re: Geotechnical Responses to City Comments
Proposed High-Rise Building
1040 Somerset Street West - Ottawa

date: May 17, 2022

file: PG2674-MEMO.14 Revision 1

Vibration Monitoring Overview

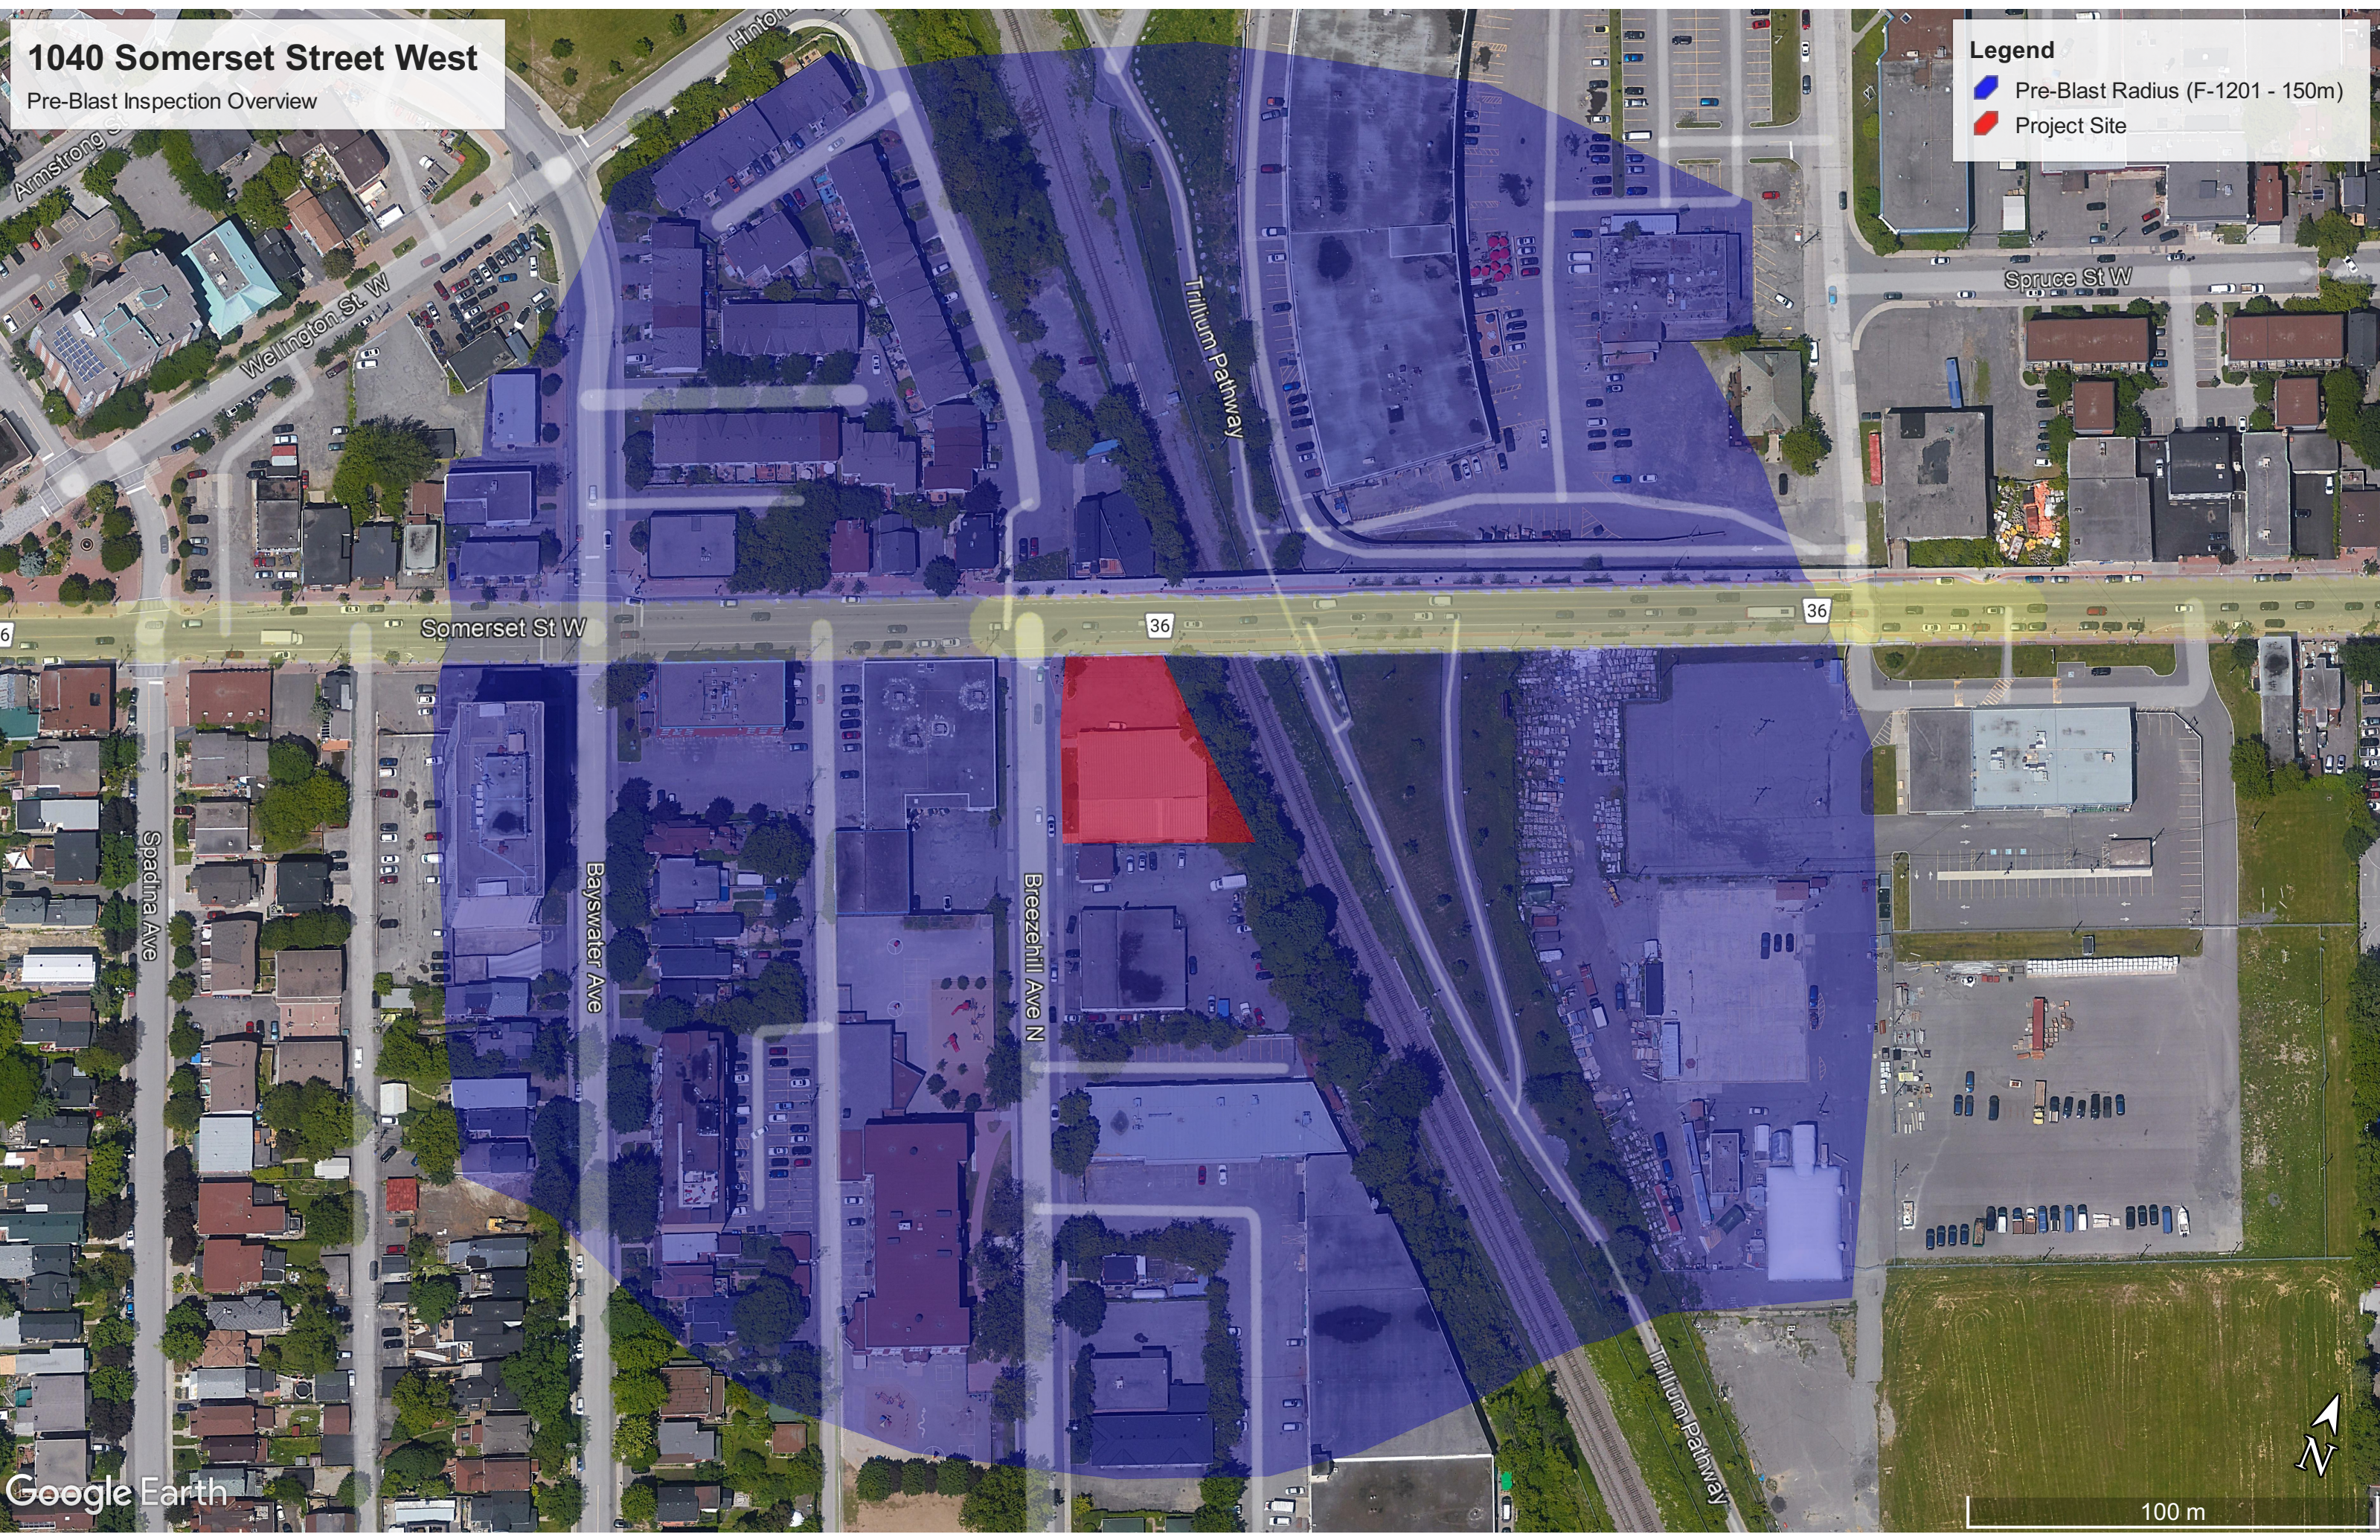
Comment: *The Peer Review report recommended using subsidence control sensors on the bridges and retaining walls. Please confirm if the recommended sensors will be used.*

Response: Yes, Paterson's Displacement Monitoring Plan (Paterson Group Memo PG2674-MEMO.12 Revision 1 dated February 7, 2022) recommends subsidence control sensors on the retaining wall, although the term "deflection monitoring points" is used in the Displacement Monitoring Plan, which is a synonym for subsidence control sensors.

A subsidence control sensor/displacement monitoring point will also be installed and monitored at the top of the bridge abutment.

Drawing
**EXCAVATION PROTECTION SYSTEM
NORTH ELEVATION
(SOMERSET St. W)**

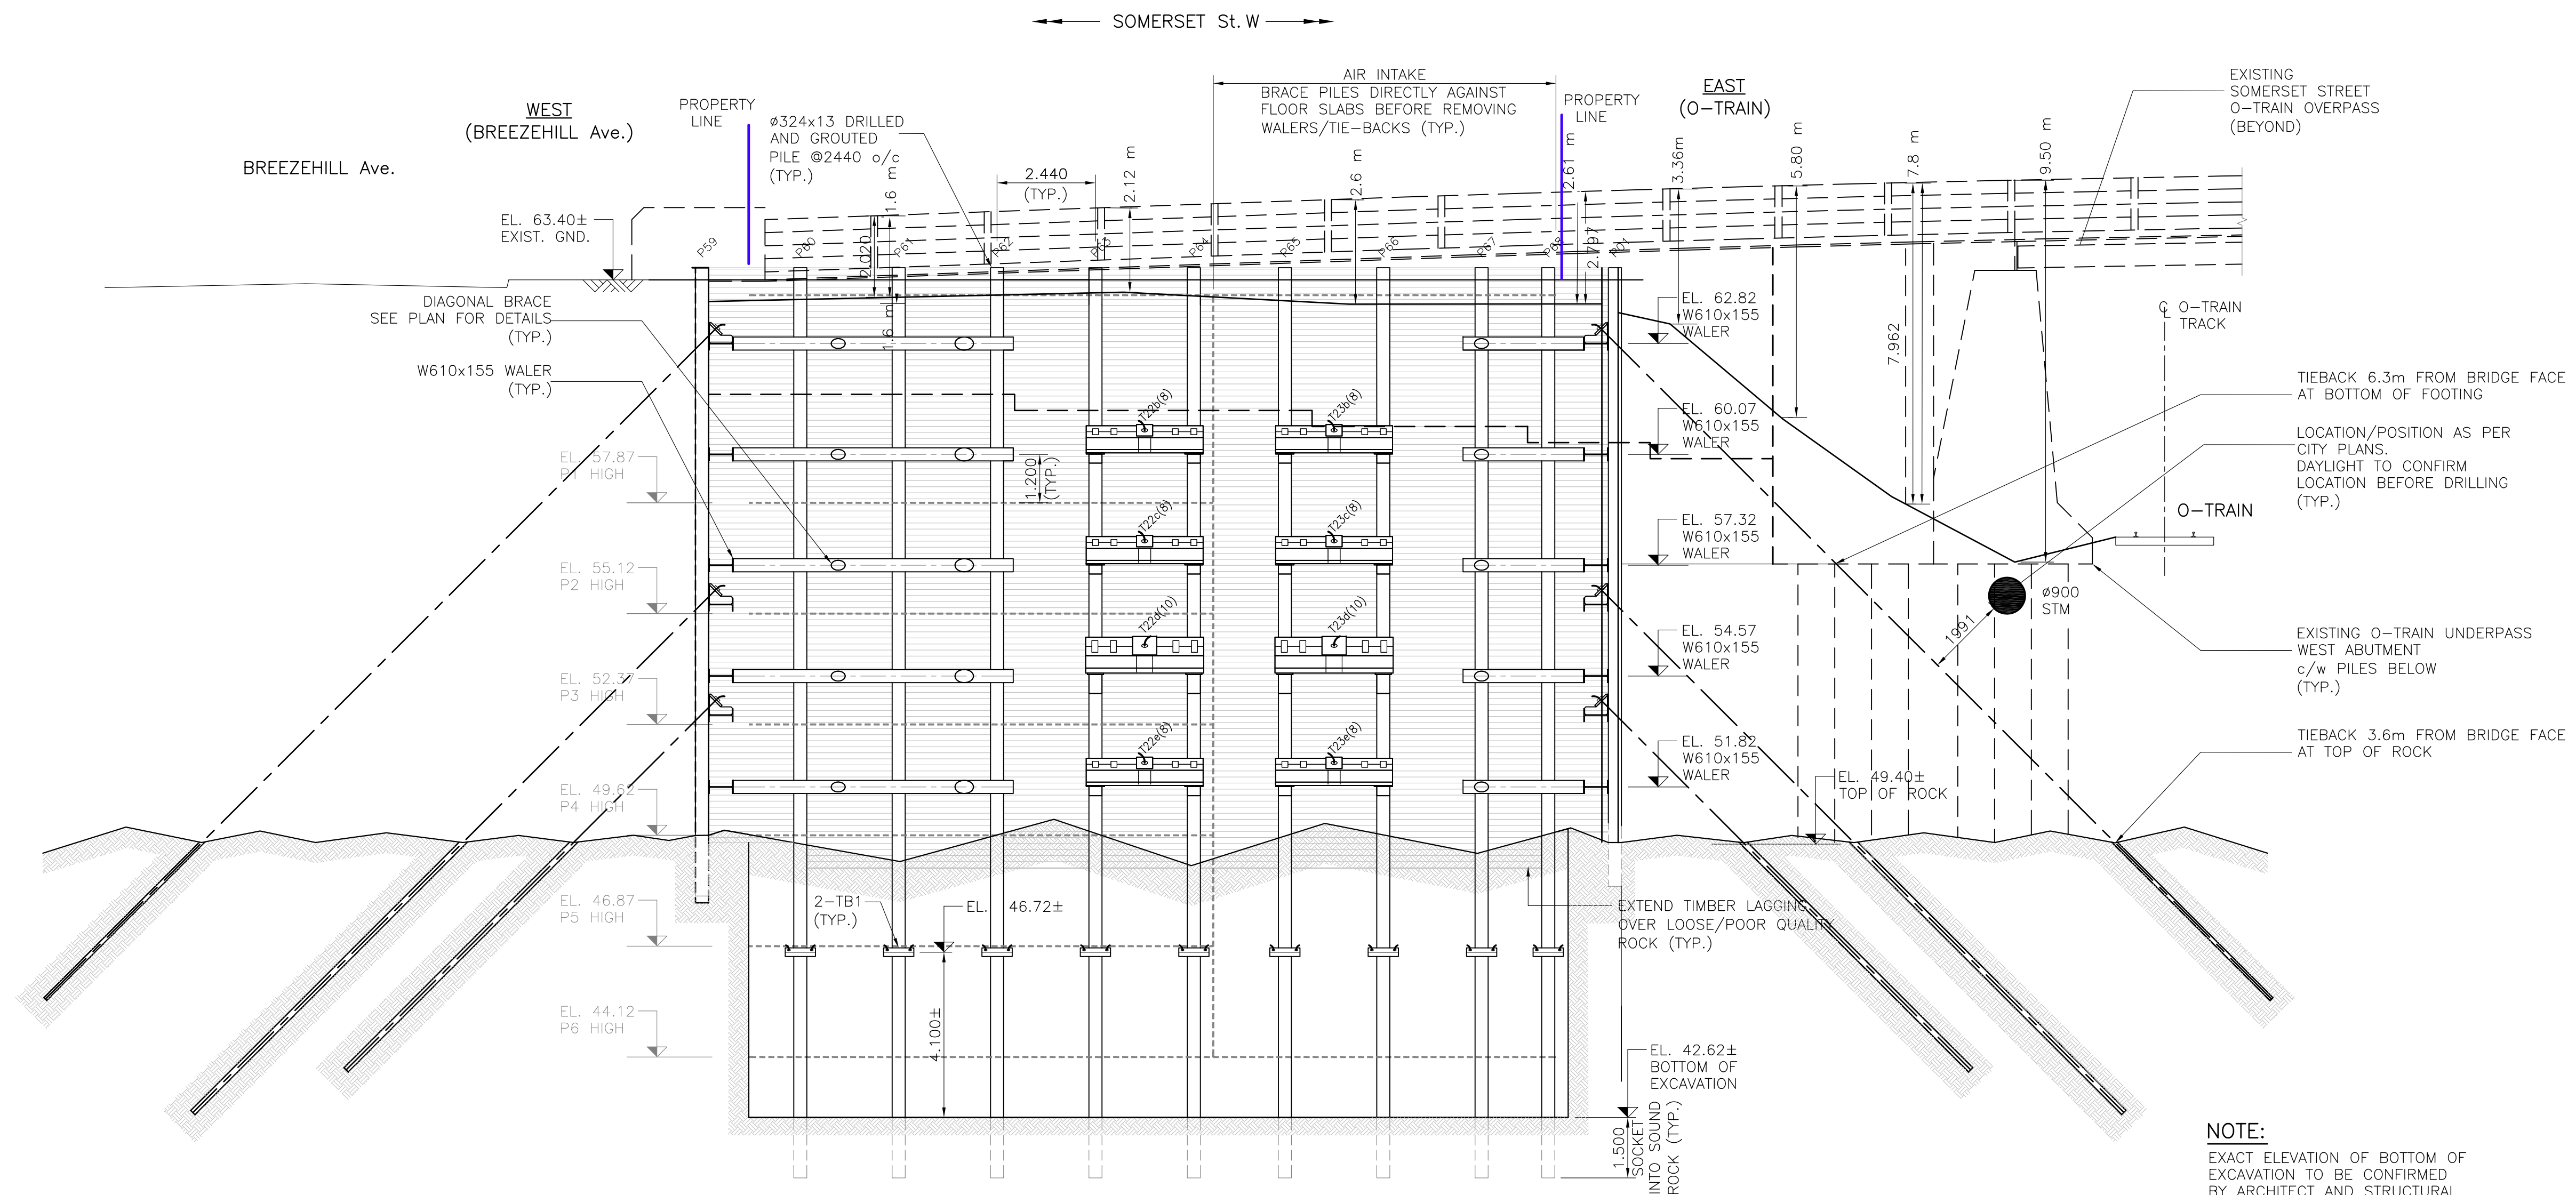
Comment: *What impact will short-term dewatering have on the proposed shoring system have on the existing bridge abutment and retaining wall structure.*

Follow-up Comment: *The Geotechnical response from Paterson has not addressed staff's comments. Staff want clear statement of the impact on bridge abutment from dewatering on this site(1040 Somerset Street). The response provided only talked about the retaining wall structure.*

Response: Short-term dewatering of the underlying soils over a 12 month period for construction will not cause excessive settlement of the shallow footings supporting the retaining wall structure of the bridge overpass, nor will it cause excessive settlement of the existing bridge abutment which is supported on timber piles.

Paterson has reviewed the soil conditions immediately below the existing retaining wall and the overall soil overburden profile as part of our geotechnical investigation. Based on our observations, the soil below the retaining wall structure consists of a compact to dense, silty sand with gravel and cobbles, which was noted to be dry followed by a stiff to very stiff, silty clay deposit with low moisture levels. The abovenoted layers are underlain by a glacial till, consisting of a silty sand with clay, gravel, cobbles and boulders. The groundwater level was encountered within the glacial till layer, which is considered to be resistant to settlement due to short-term dewatering based on our observations and testing results.

Further, short-term dewatering will not reduce the frictional and/or end-bearing resistance of the timber piles which are supporting the overlying bridge abutment.

It is also understood that a temporary shoring system will be installed adjacent to the bridge abutment and retaining wall structure which will allow dewatering of the supported soils. However, it is expected that the extent of dewatering will be limited due to the soil consistency. Also, the glacial till layer is not expected to undergo any significant settlement (ie.- less than 5 mm) due to the short-term dewatering. Therefore, the shallow footing supported retaining wall structure and the timber pile-supported bridge abutment will not undergo excessive settlement (ie.- less than 5 mm) due to the short-term dewatering associated with the proposed excavation program for the subject site.
